# Rezoning Transportation Analysis

Petition Number: #2022-099

## Revision Log:

Date	Description
11-28-22	First Review (IW)
12-22-22	Second Review (IW)
01-26-23	Third Review (IW)
10-25-23	Fourth Review (NK)

RZ-1

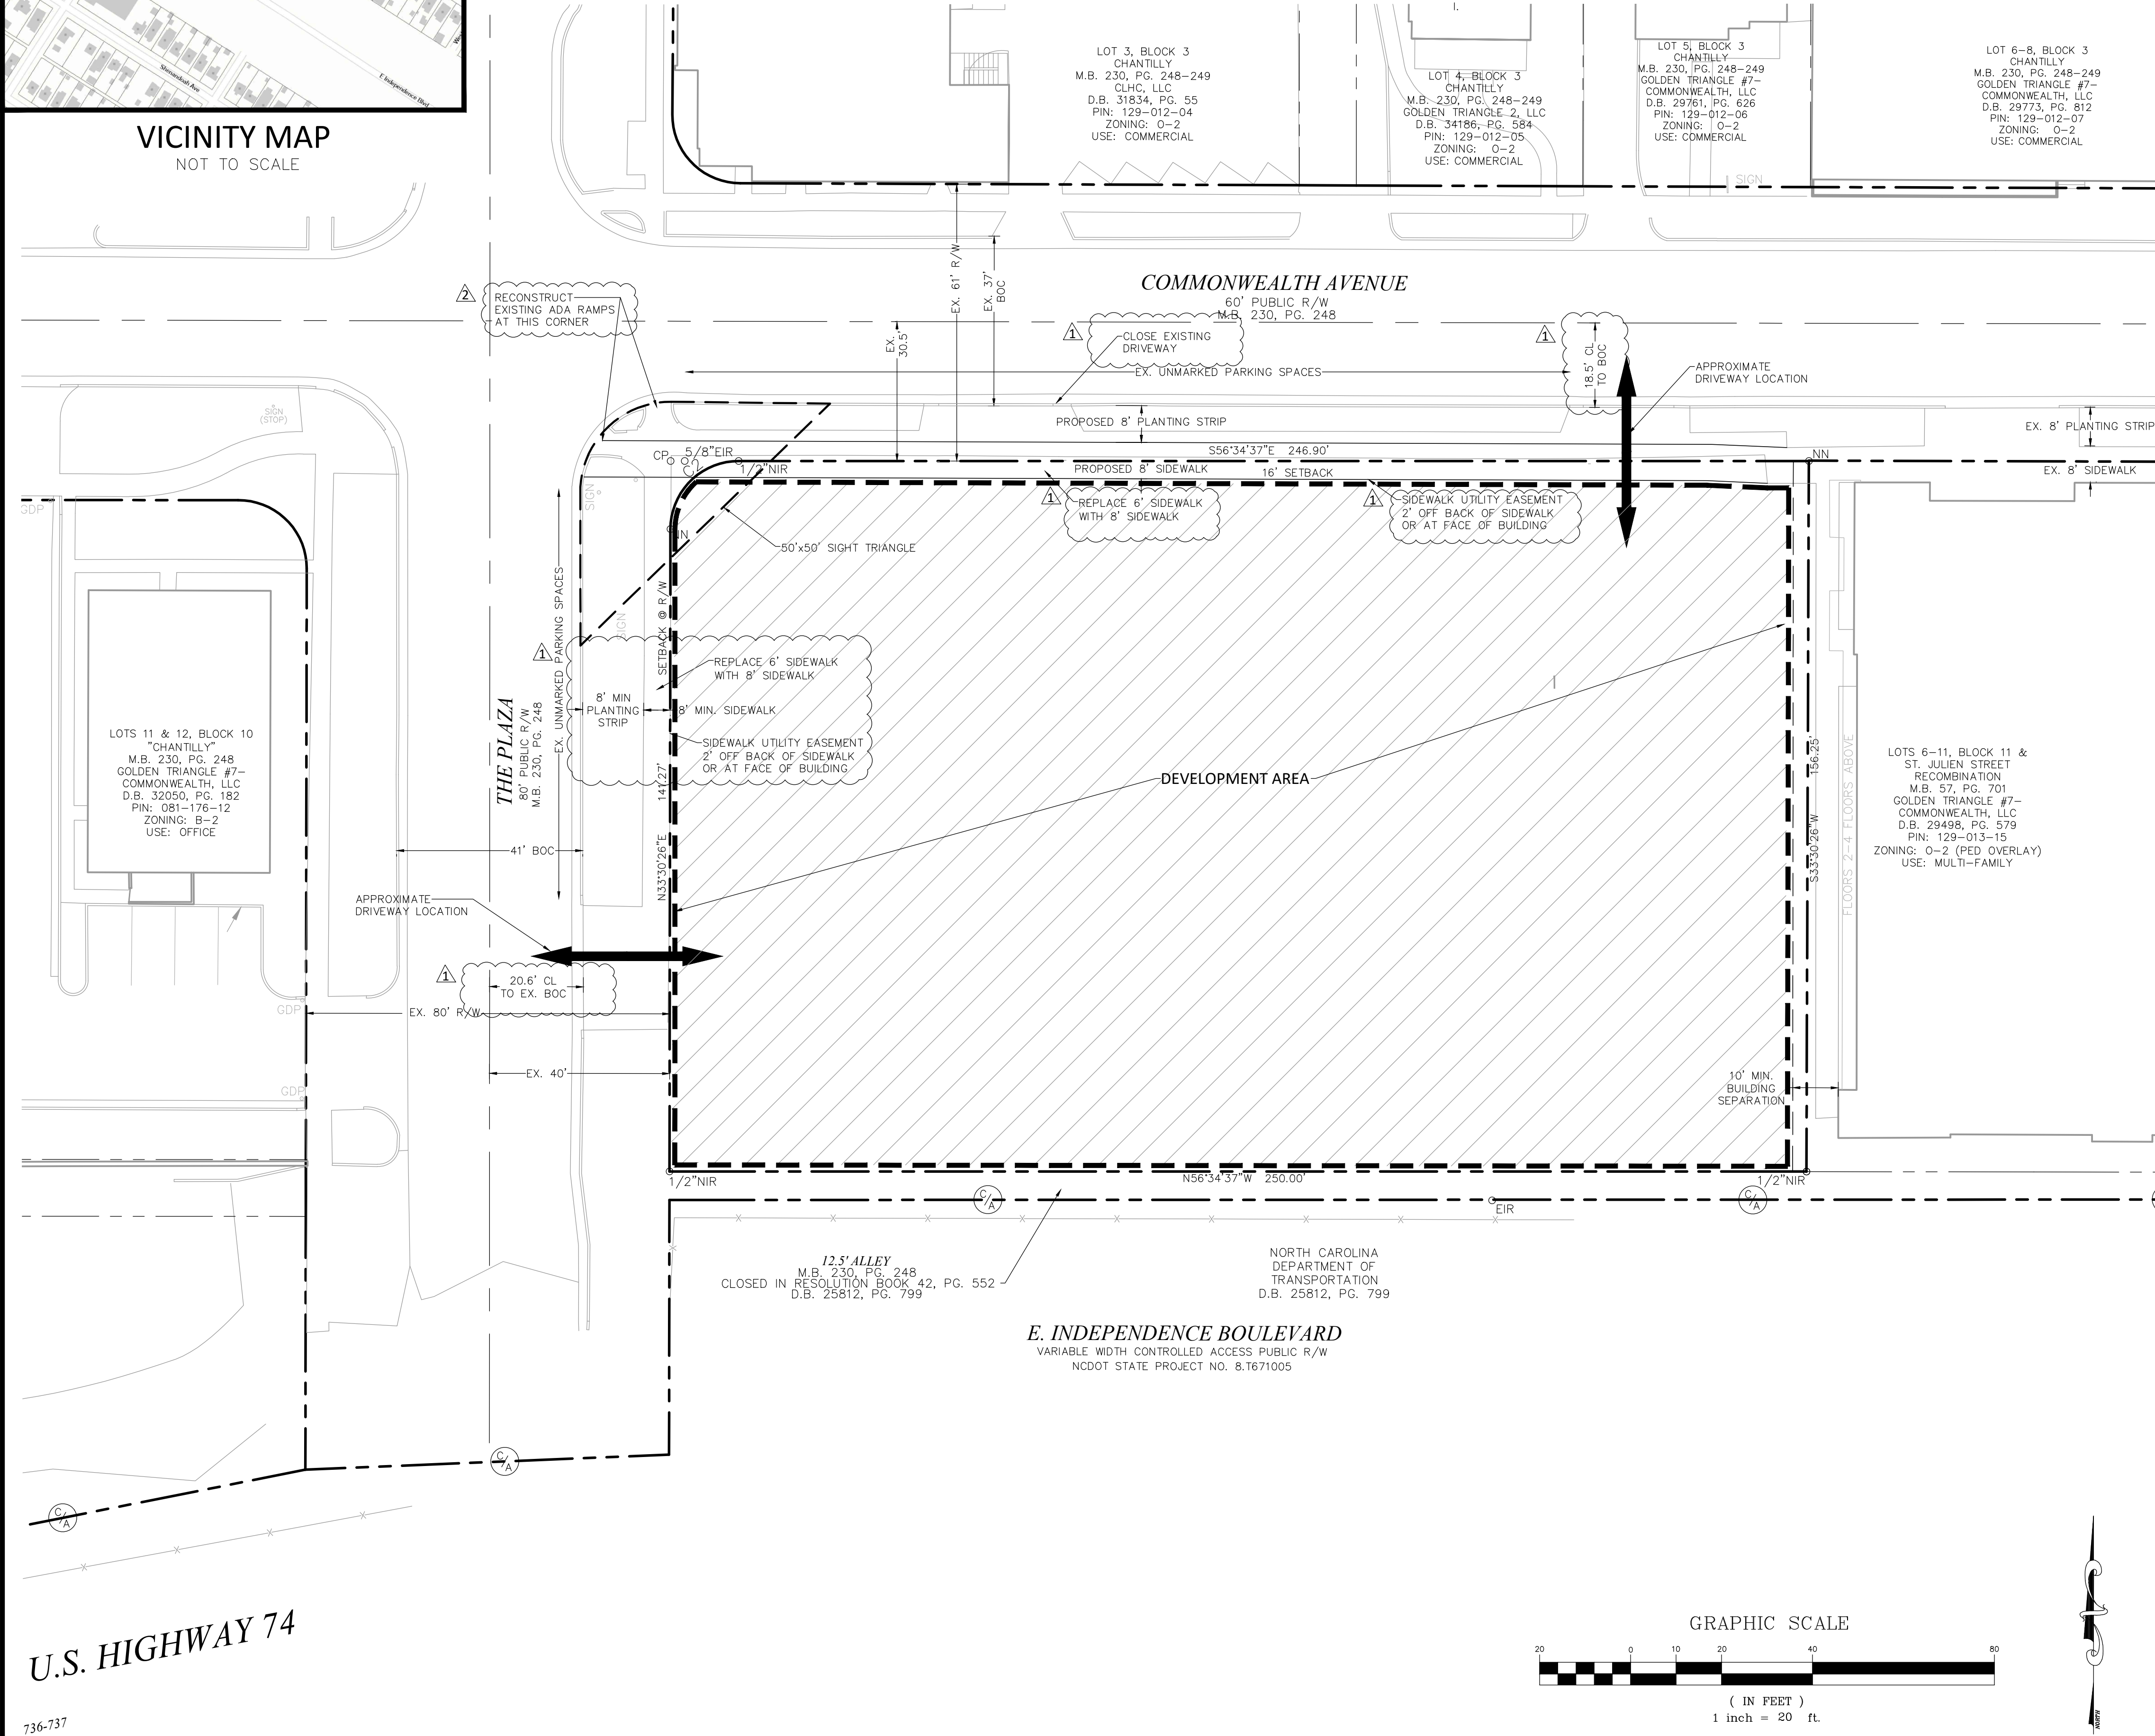
1. ~~**Curbline:** The proposed zoning district has a setback measured from back of the existing or proposed future curbline.~~

a. ~~**Commonwealth Avenue:** The future location of curb and gutter is in its existing location.~~

b. ~~**The Plaza:** The future location of curb and gutter is in its existing location~~

~~Label and dimension the curb and gutter from the centerline for each road on the site plan.~~

4. ~~Revise site plan and conditional note(s) to commit to dedicate 2 feet of sidewalk utility easement behind proposed sidewalk along Commonwealth Avenue and The Plaza. The site plan shall label and dimension sidewalk utility easement.~~

5. ~~Revise site plan and conditional note(s) to specify what portion of the sidewalk along The Plaza will be proposed vs existing.~~

6. ~~Revise site plan and conditional note(s) to show existing western driveway to be removed and curb and gutter to be replace driveway on Commonwealth Avenue.~~

7. ~~CDOT is requesting that the petitioner revise the site plan and conditional notes to commit to updating the ADA ramps at corner of The Plaza and Commonwealth Avenue.~~
8. ~~A site plan note(s) specifying dedication and fee simple conveyance of all rights-of-way to the City before the site's first building certificate of occupancy is issued as needed. CDOT requests rights-of-way set at 2' behind back of sidewalk where feasible.~~

The petition is located on the south side of Commonwealth Avenue, a City-maintained major collector east of The Plaza, a City-maintained local street. A Traffic Impact Study (TIS) is not needed for this site. The petition is committed to upgrading streetscape along The Plaza and Commonwealth Avenue and upgrading off-site ADA Ramps. No further revisions are required.
